MECKLENBURG COUNTY
Park and Recreation Department

MEMORANDUM

DATE: December 19, 2007

RE: Rezoning Petition # 2008-035 (PID #s 075-105-43; 075-105-30; 075-105-37;
079-044-02)

KOHLER AVENUE RE-ZONING PLAN SUBMITTAL FOR PUBLIC HEARING

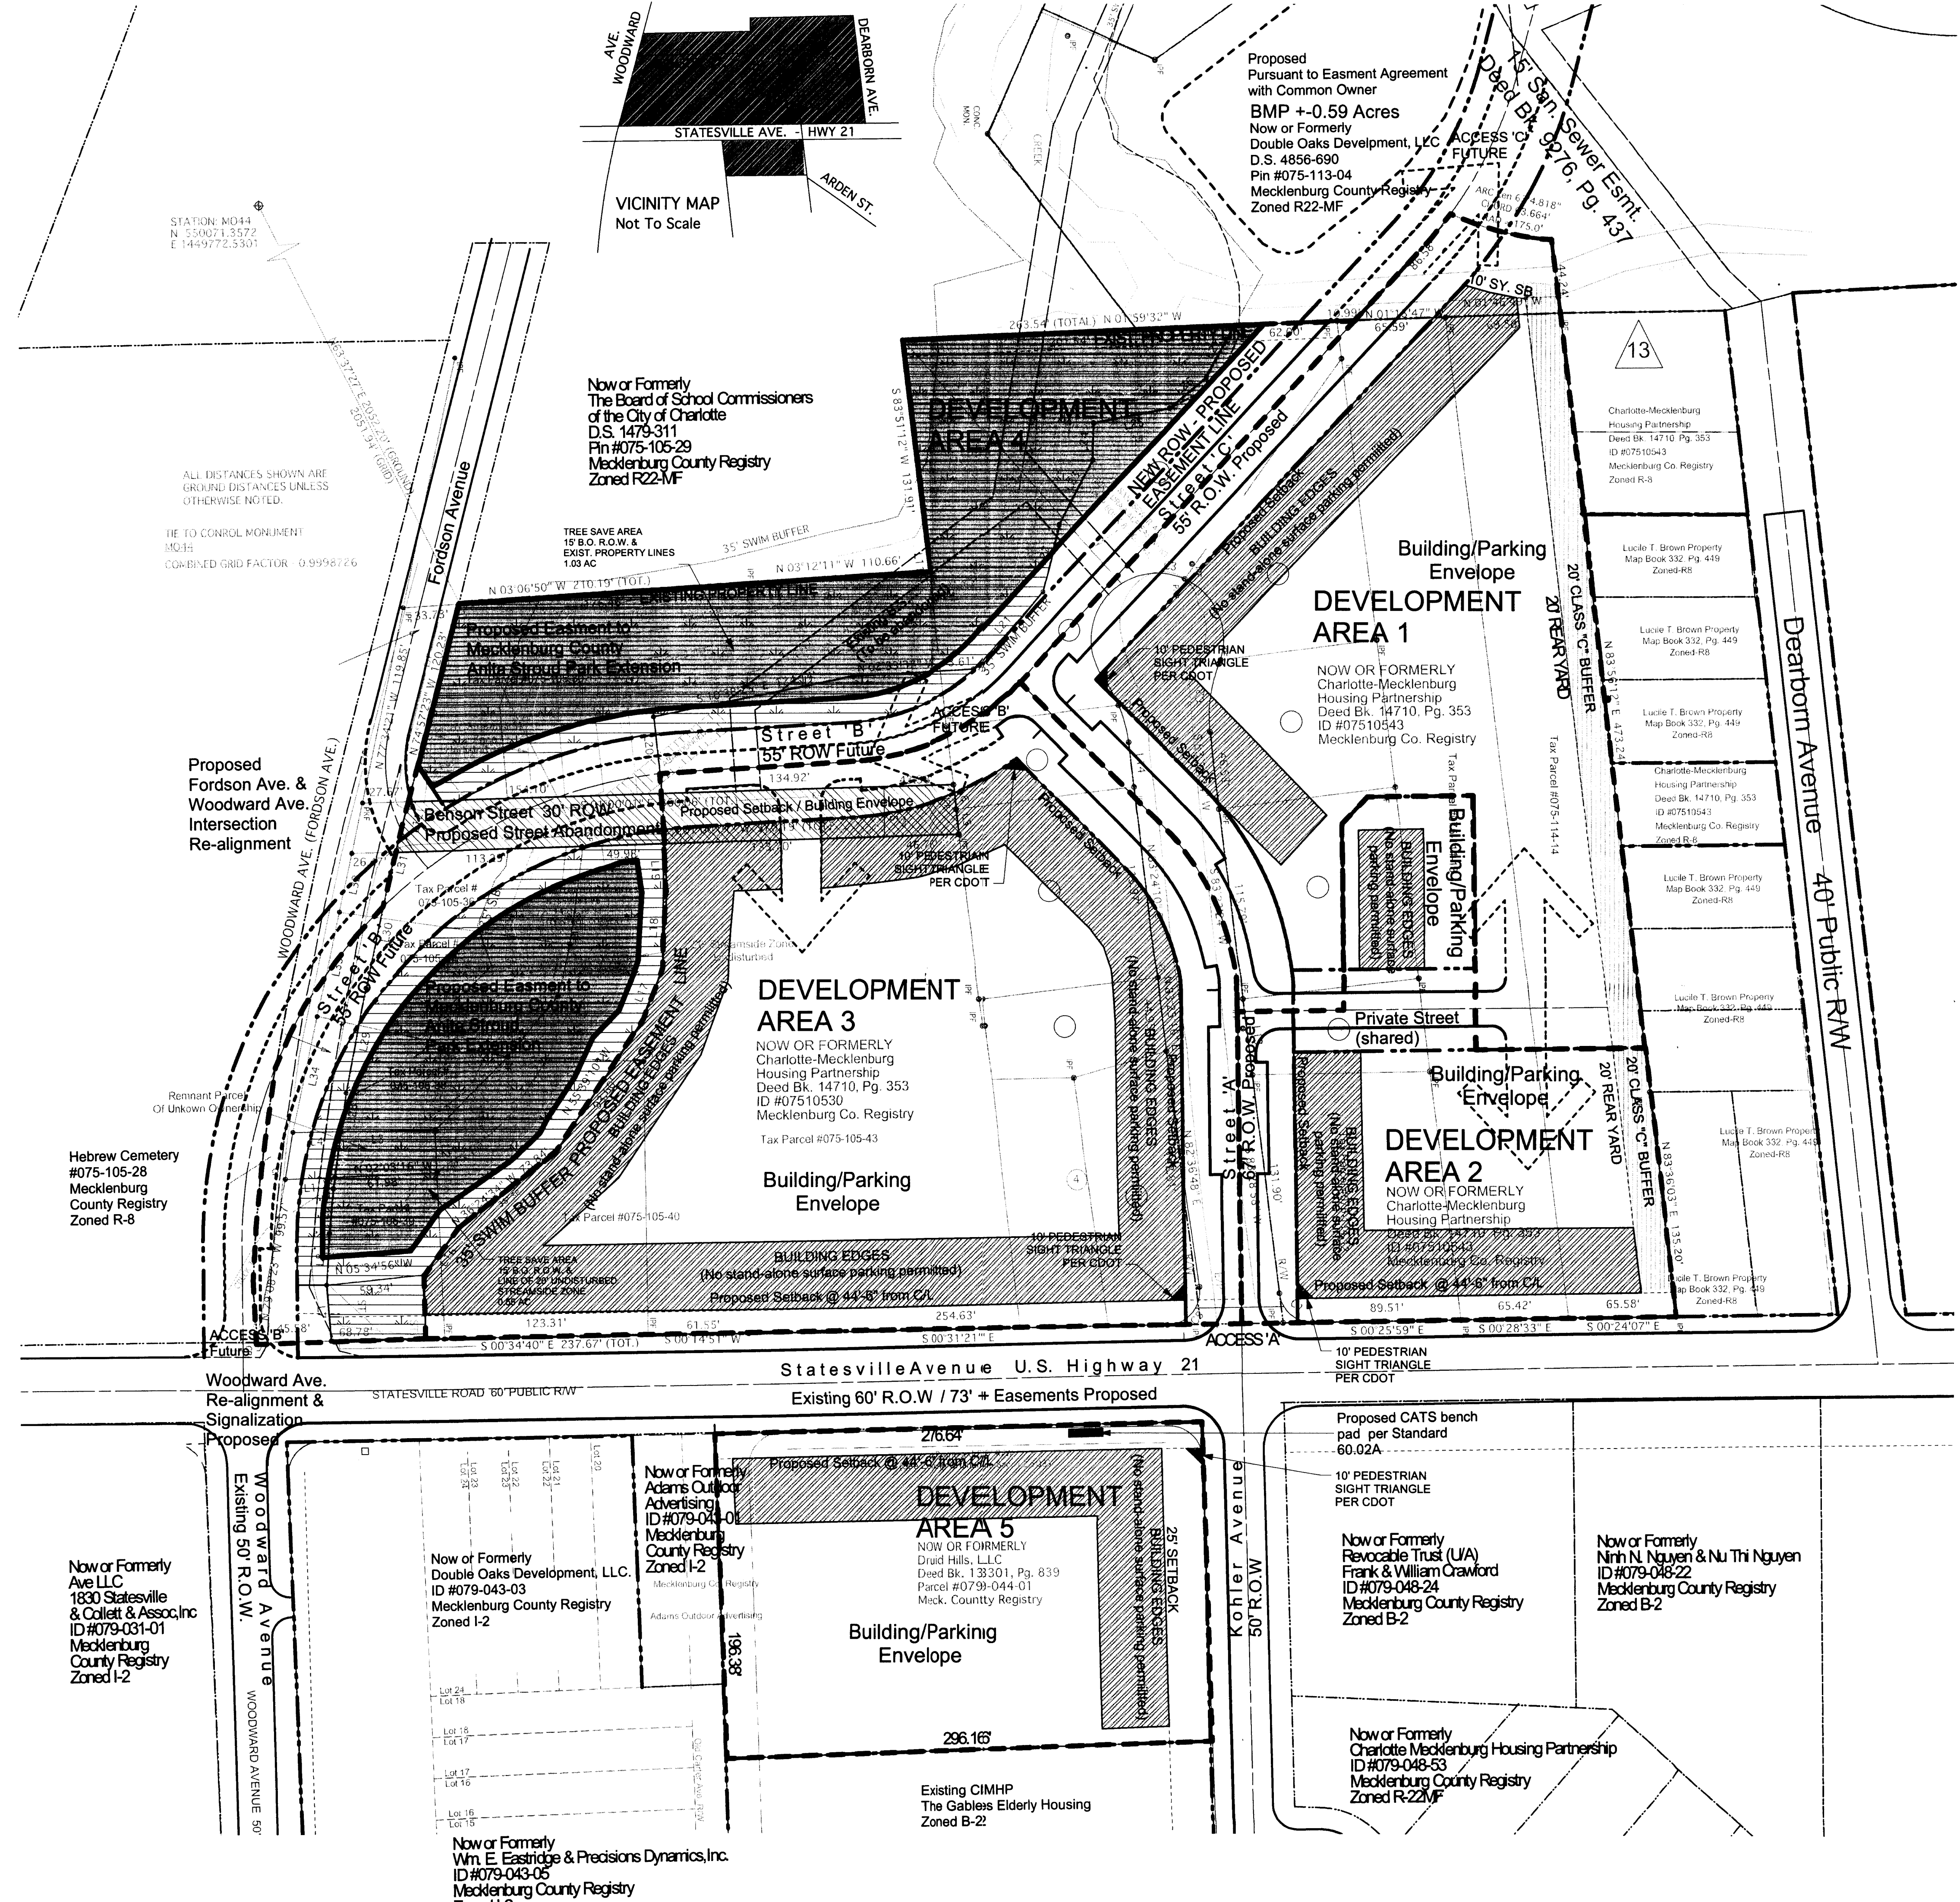
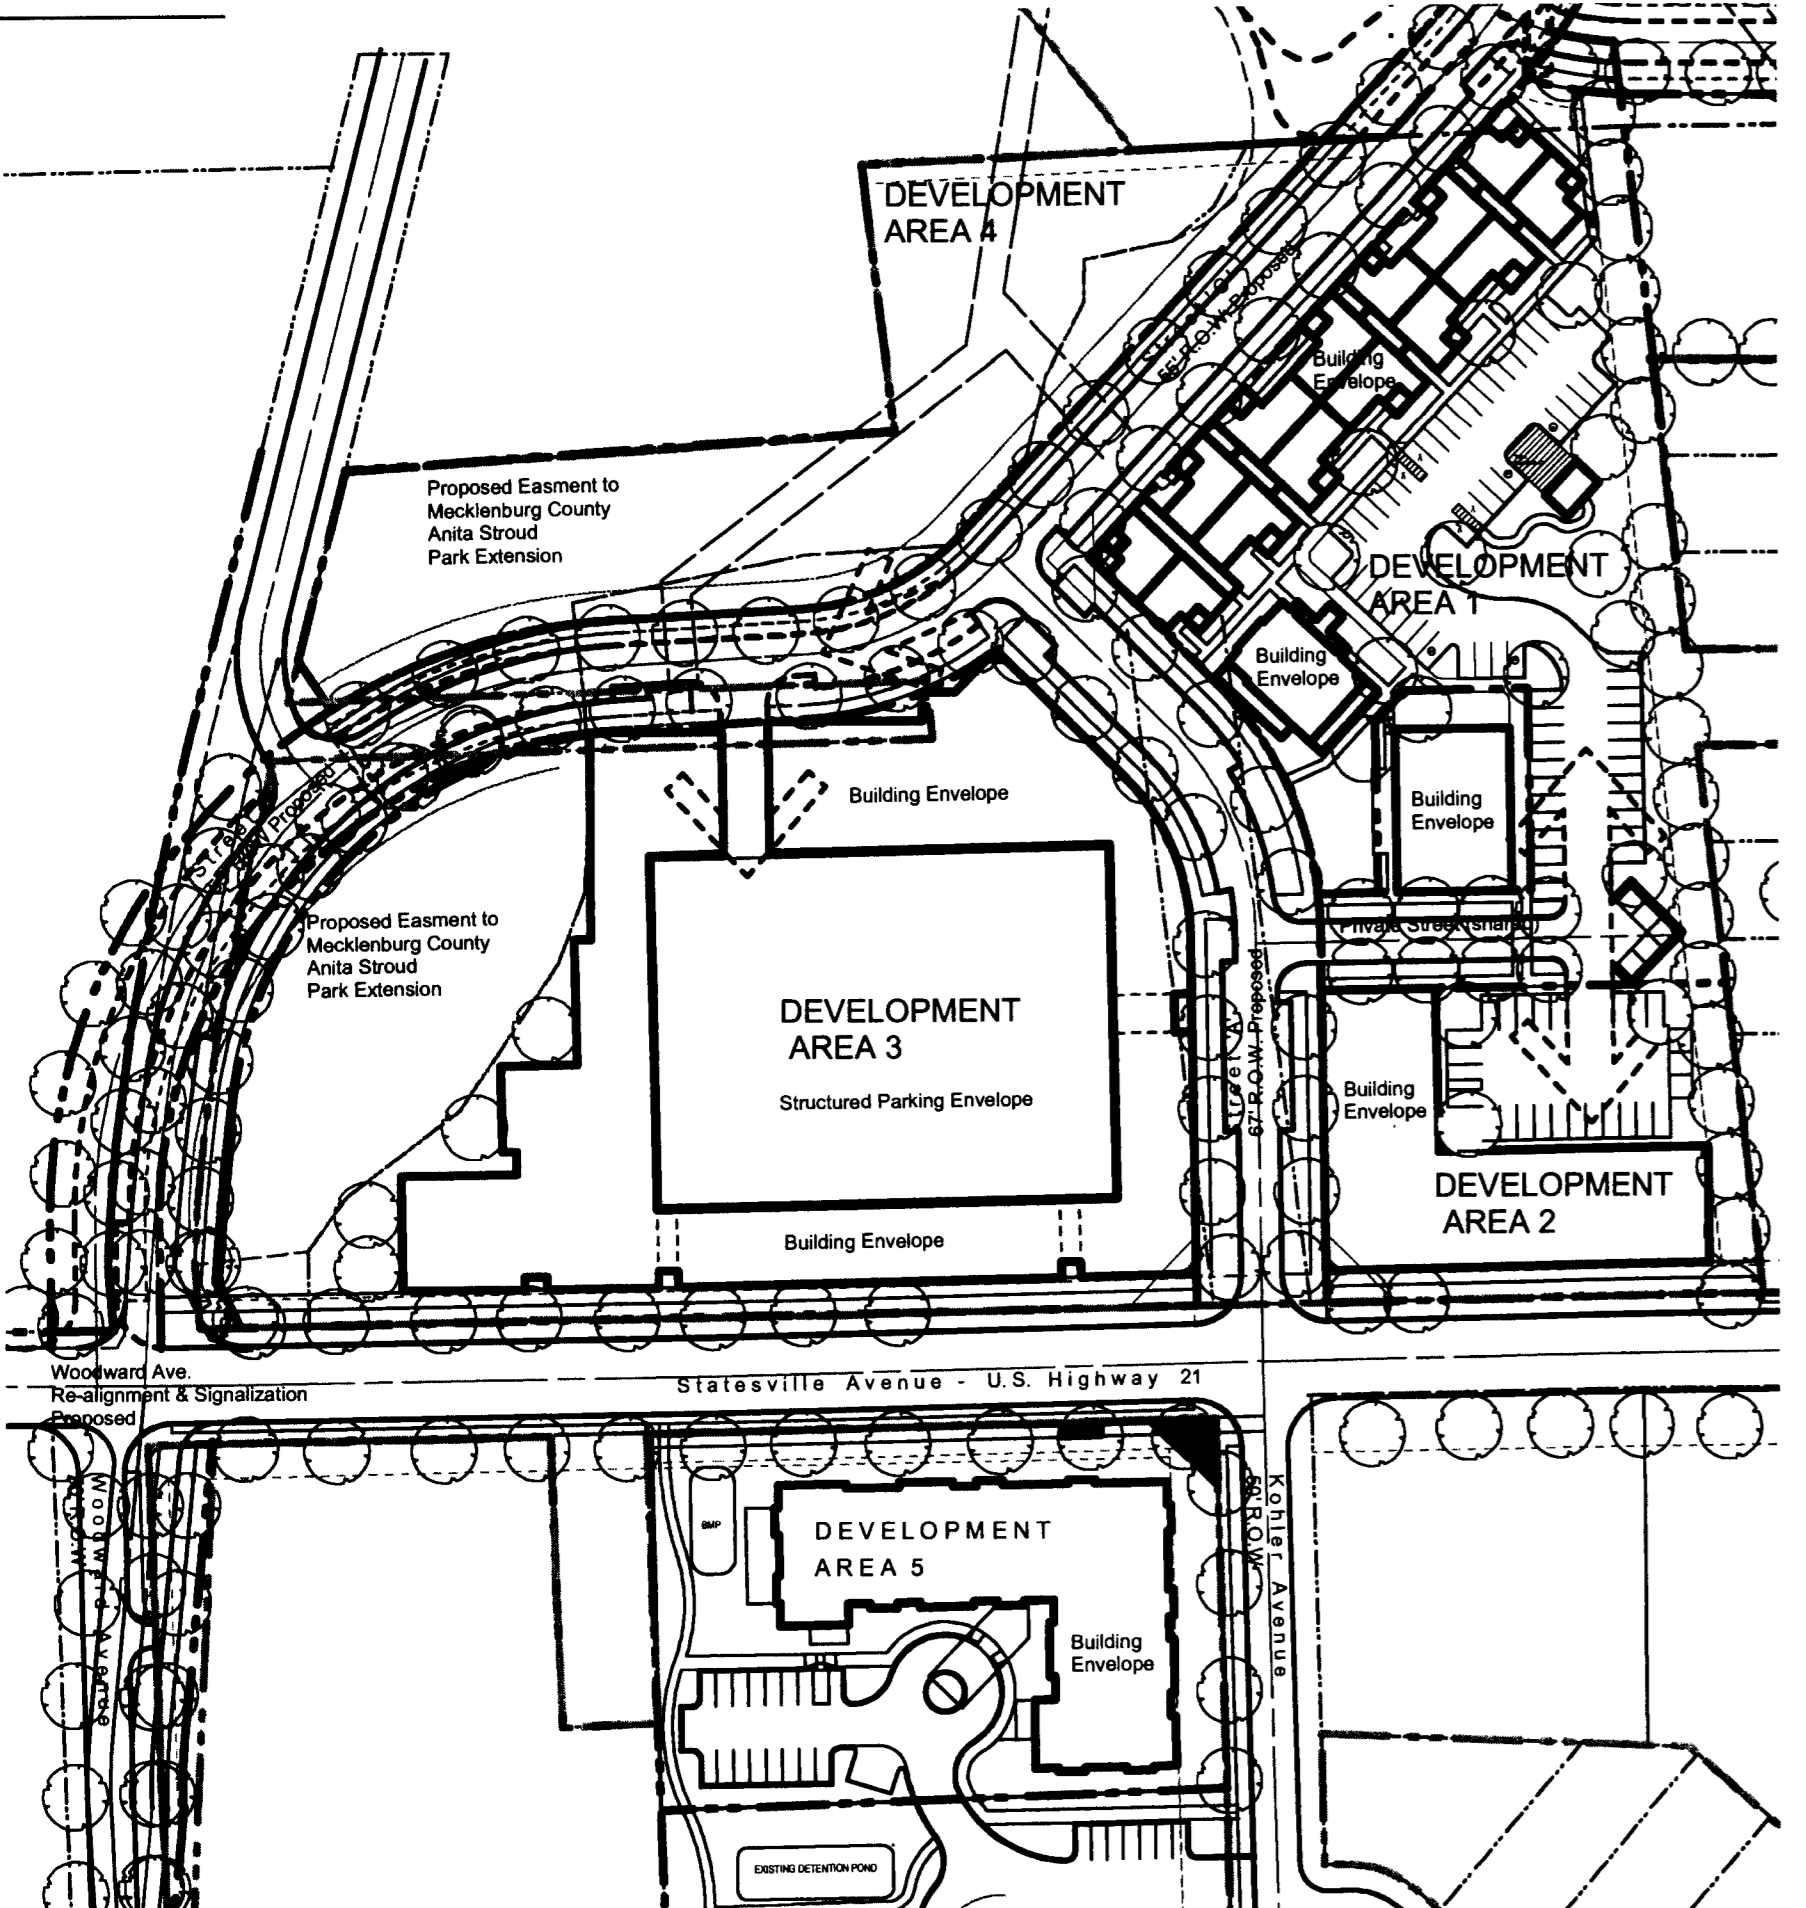
In most cases MCPR requests that the petitioner dedicate the FEMA floodplain or S.W.I.M. buffer to the County for floodplain protection and greenway development. On the site plan dated 11/9/07, the petitioner has offered an easement encompassing the 35' SWIM buffer. MCPR is appreciative of this offer. However, this site presents challenges that require additional easements or dedications for a greenway to be constructed. MCPR requests an easement or dedication of the entire area of "Development Area 4" that is on the northern side of the proposed Woodward Avenue. This will provide additional area to route the greenway and also allow for a connection to the public sidewalk system at the intersection of Woodward Avenue

and Kohler Avenue. Additionally, MCPR requests that the reconstructed Woodward Avenue bridge over the Irwin Creek tributary be built to accommodate an 8' wide greenway trail with a minimum clearance of 7'6" underneath the bridge on the eastern side of the tributary. MCPR also requests an easement or dedication of additional land at the intersection of Woodward Avenue and Statesville Avenue to enable the greenway to fully reach the intersection. The additional dedication should be a minimum of 180 square feet and should form a straight line between the 35' SWIM buffer easement line and Statesville Avenue as shown on the site plan.

MCPR also wishes to note that additional land outside of the area encompassed in this rezoning will be required to connect the proposed easements to Anita Stroud Park. This approximately 200' gap exists north of the area entitled "Development Area 4" and adjacent to the proposed BMP as shown on the site plan.
